OXFORDSHIRE COUNTY COUNCIL'S RESPONSE TO CONSULTATION ON THE FOLLOWING DEVELOPMENT PROPOSAL

Application no: 21/04187/SCOP

Proposal: Scoping Opinion - EIA scoping exercise for Land East of Park View, Woodstock

Response date: 8th February 2022

Figure 1: Site boundary

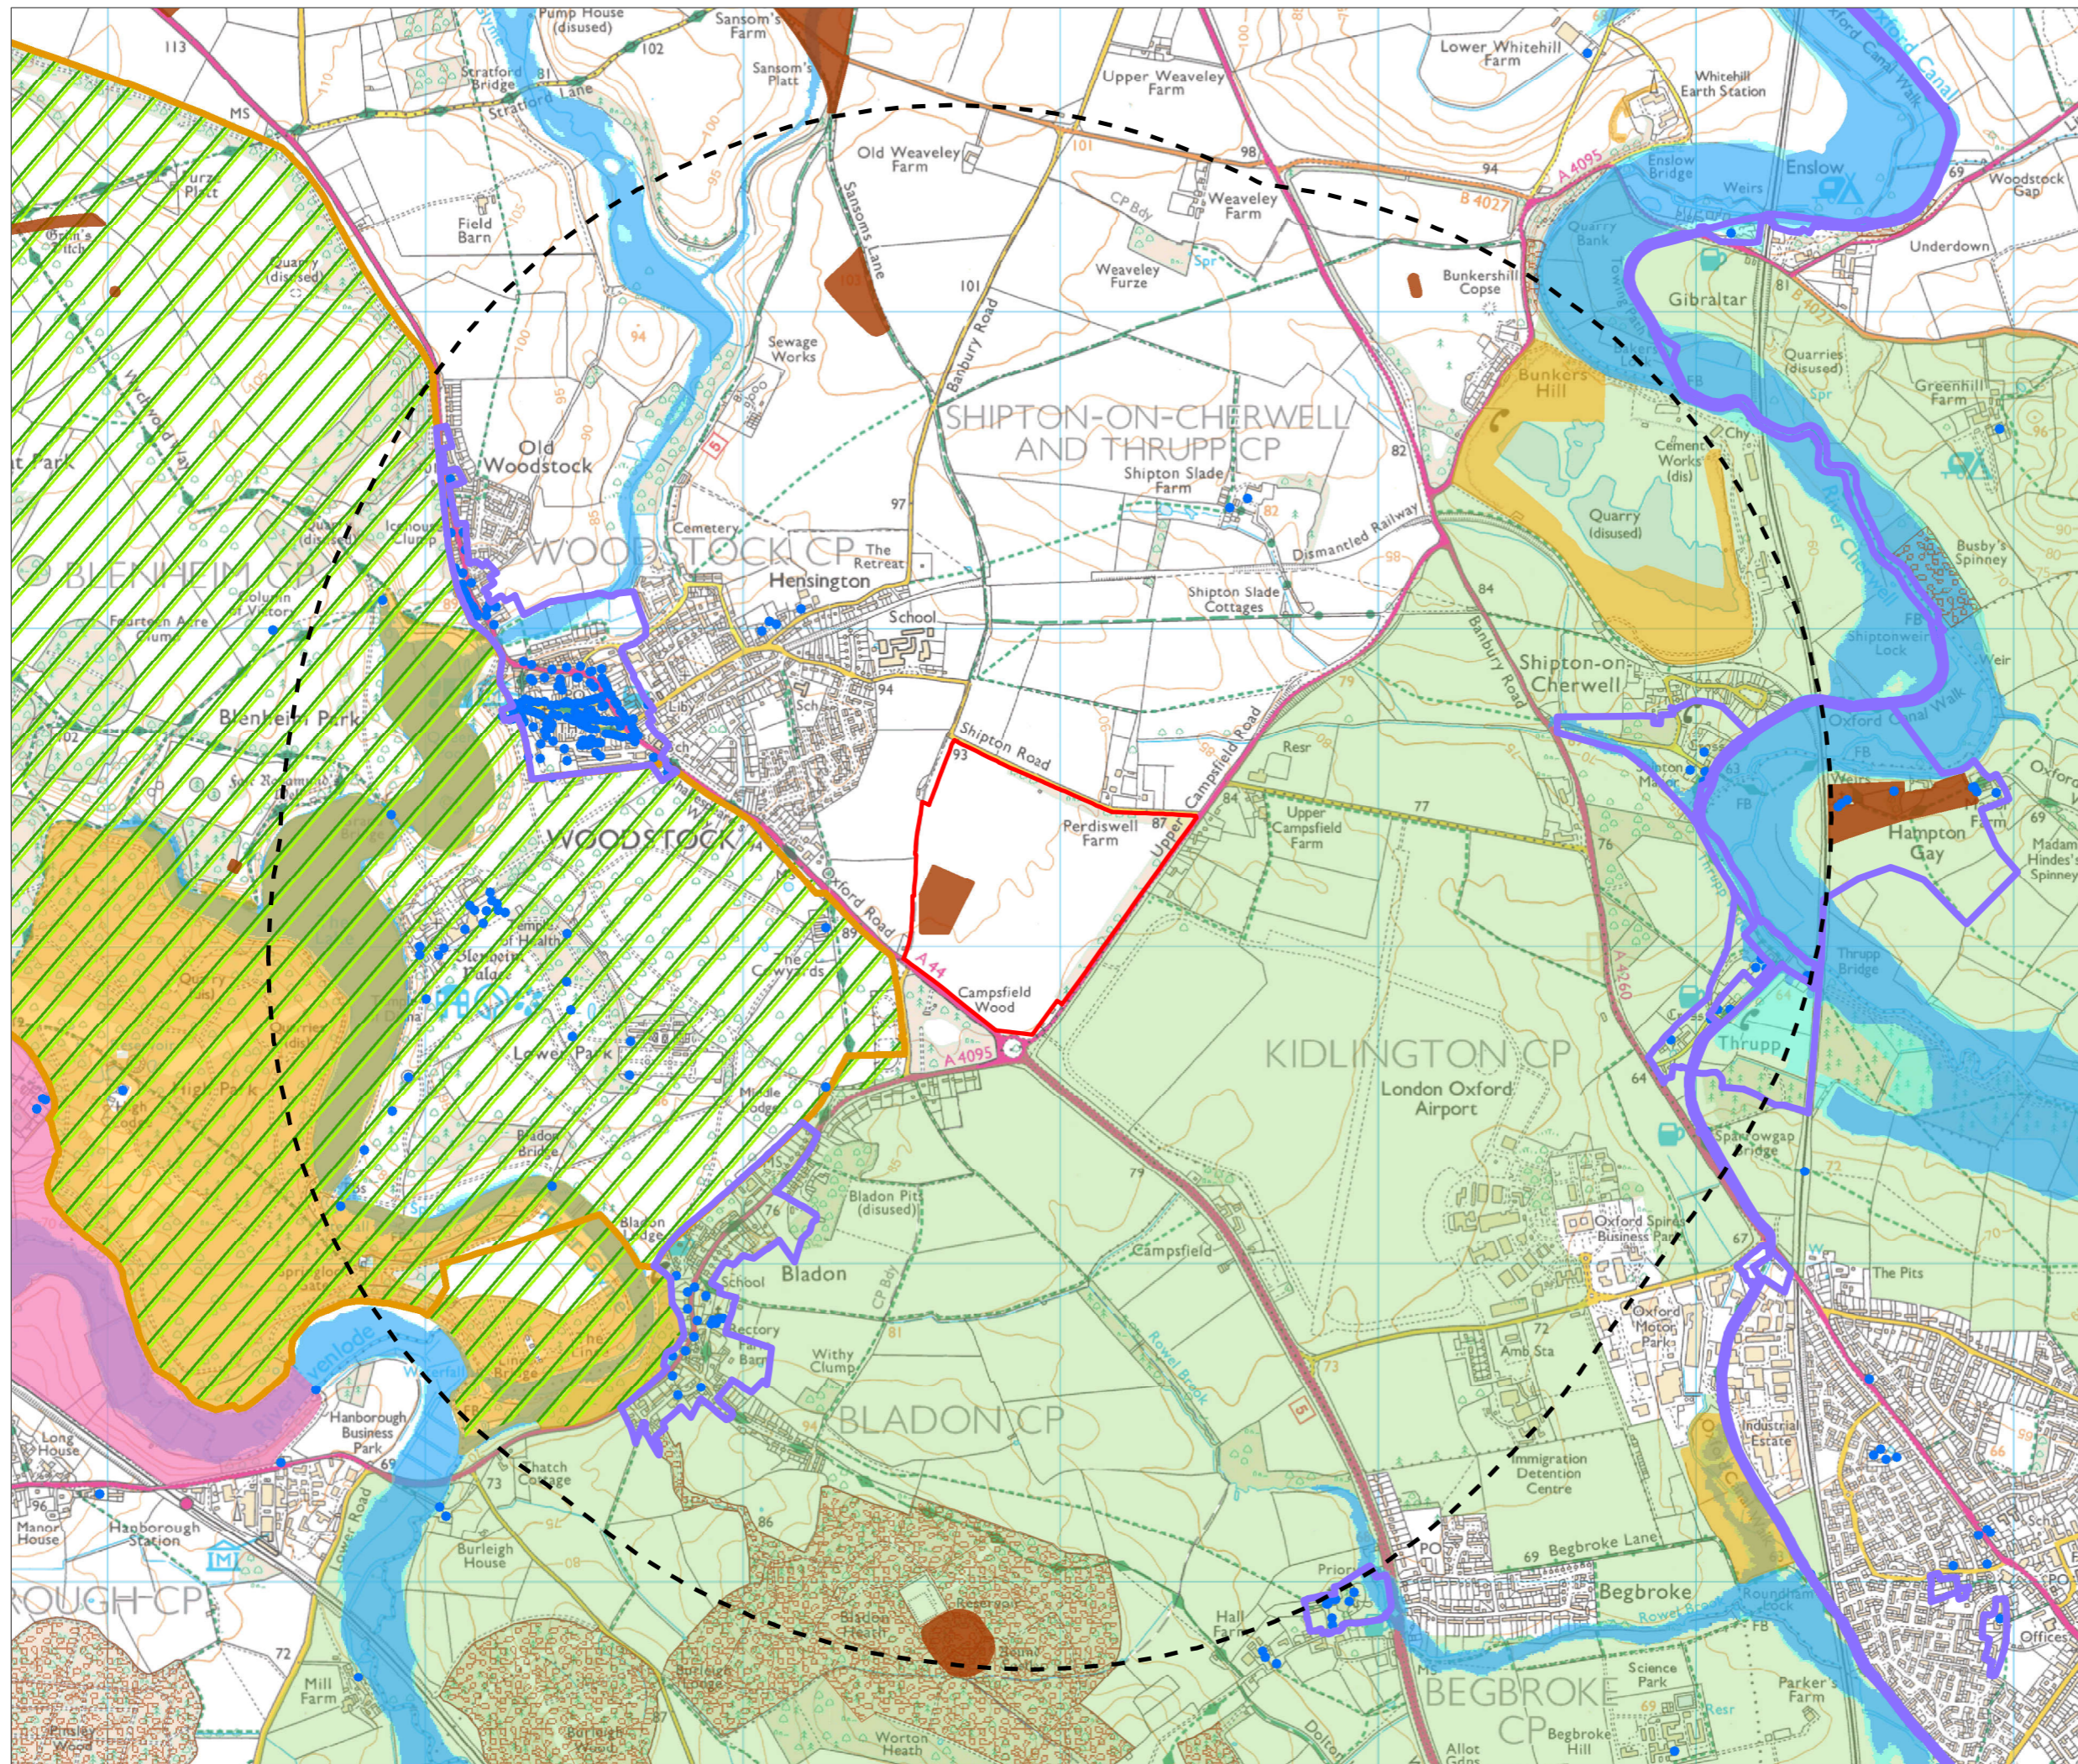
The site location plan has been included in the scoping report as Figure 1. The report goes on to suggest that a new vehicular access junction will be formed off the A4095 Upper Campsfield Road with a connection through to Cowells Road. The type of junction with the A4095 has however not been stated which is thought shall be a key consideration to the network operation.
